**KIRKLEES METROPOLITAN COUNCIL
INVESTMENT & REGENERATION SERVICE**

Reference No: 2019/62/94093/E

Site Address: Hill View Cottage, 5, Timberwood, Kirkburton,
Huddersfield, HD8 0PB

Description: Erection of single storey front extension (within a
Conservation Area)

PROPOSED
FRONT ELEVATION
SCALE 1:100

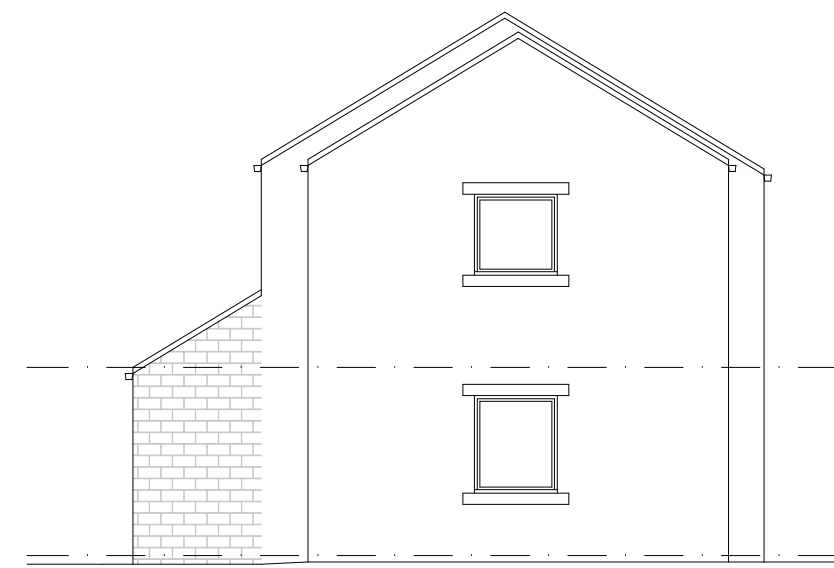
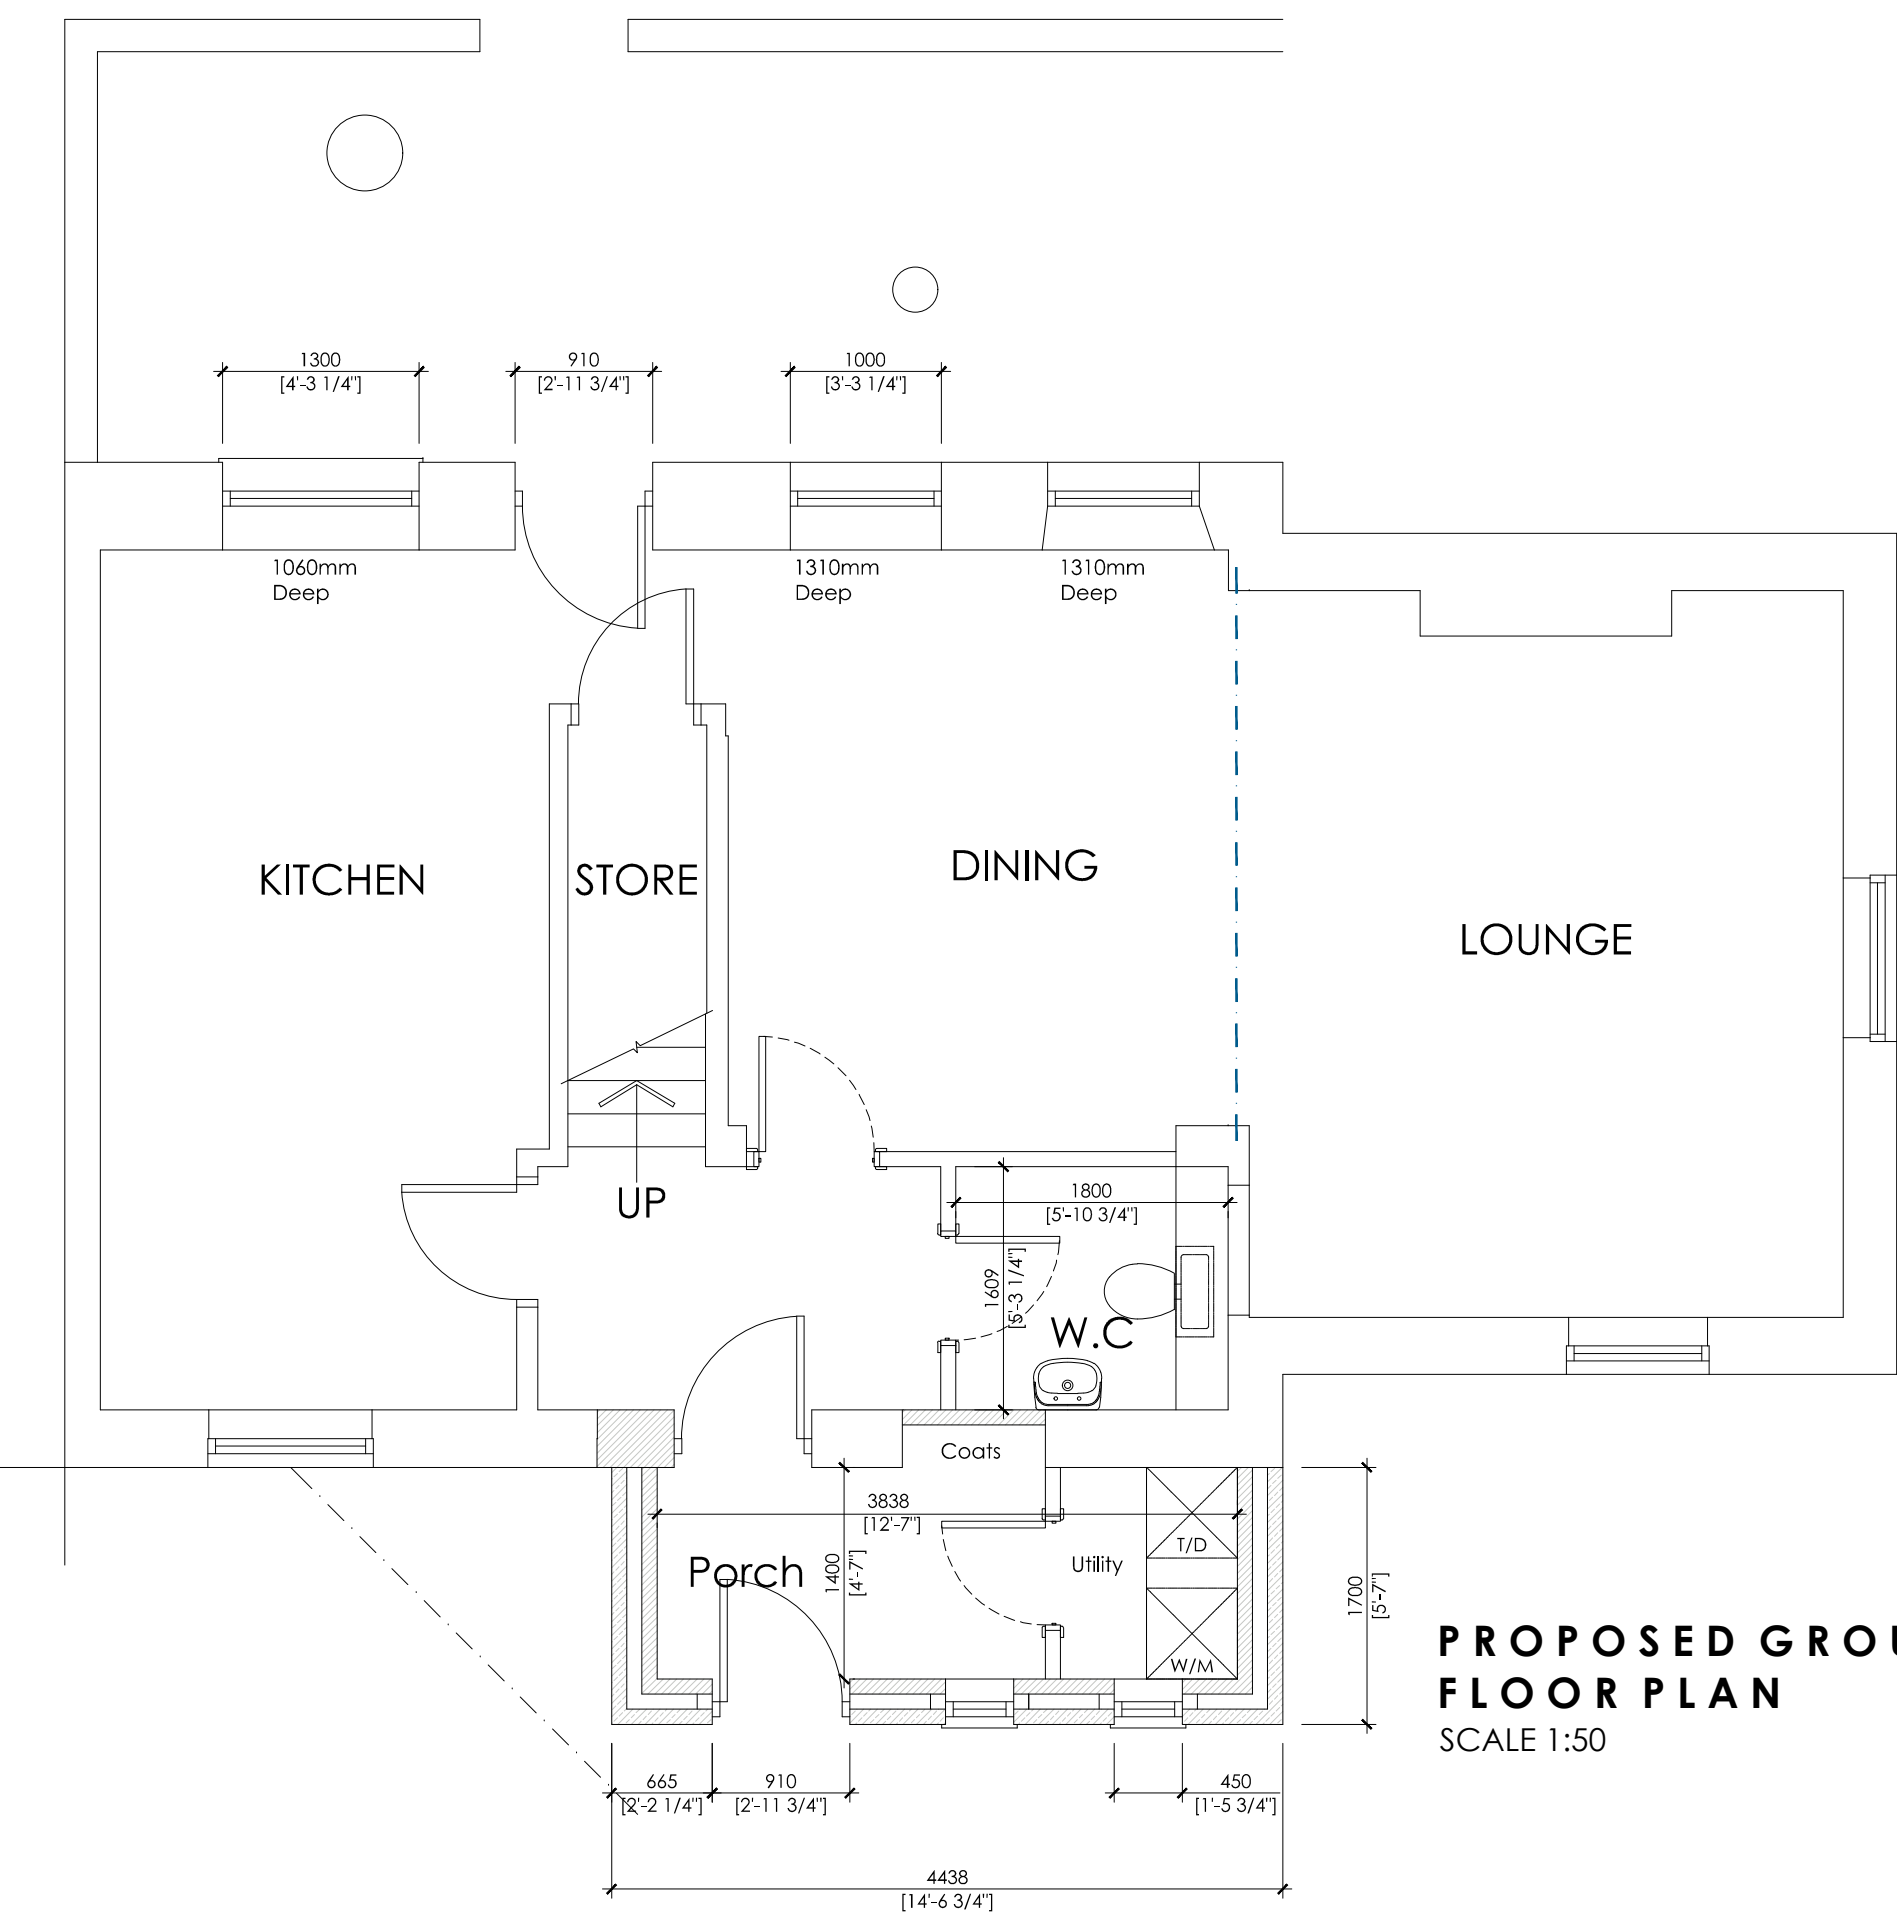
The development proposal is for a single storey front extension comprising a porch and a utility room. This extension would be modest in scale compared to the host property. The facing and roofing materials are proposed to match the existing building on site. The extension would have a simple mono-pitched roof with two small windows. This is considered a satisfactory design that would preserve the appearance of the application property and in keeping with the semi-rural character of its immediate surroundings. Therefore, the proposal would be acceptable in scale, design and materials, complying with policies LP24 and LP57 of the KLP and chapter 12 of the NPPF.

The proposed extension would project from the external front wall of the host property by 1.7m, setting back from the internal side wall by 3.5m. An extension of this scale is not considered to cause unacceptable overbearing and overshadowing impacts on the adjoining property no.6 Timberwood and its garden.

PROPOSED
REAR ELEVATION
SCALE 1:100

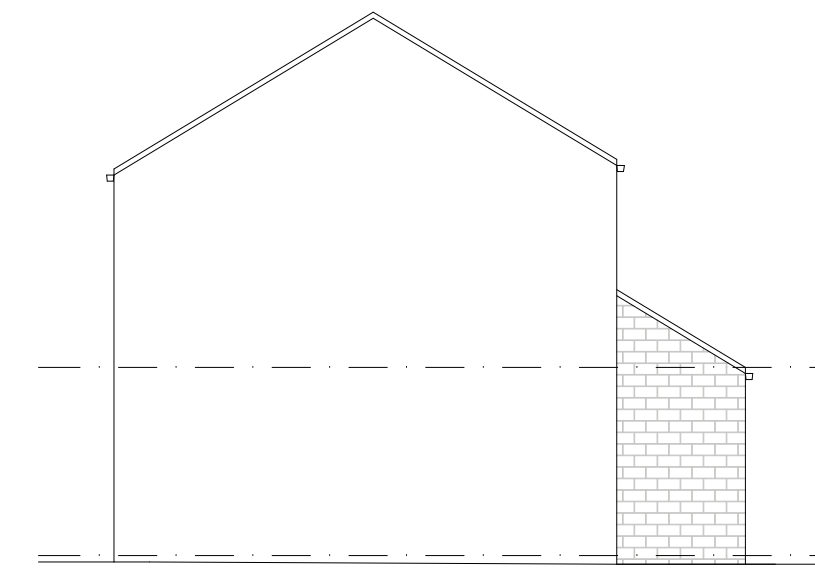
The proposed drawing indicates that the existing painted timber door in the rear elevation of the host property would be replaced by a glass door. This alteration is not currently included in the application description and therefore not assessed in this application. However, such an alteration may be carried out under Class A of Part 1 of Schedule 2 of the GPDO. For the sake of clarity, a footnote should be inserted to the decision notice to state that the permission solely relates to the front extension.

NOTE: This planning permission relates solely to the erection of a single storey front extension.
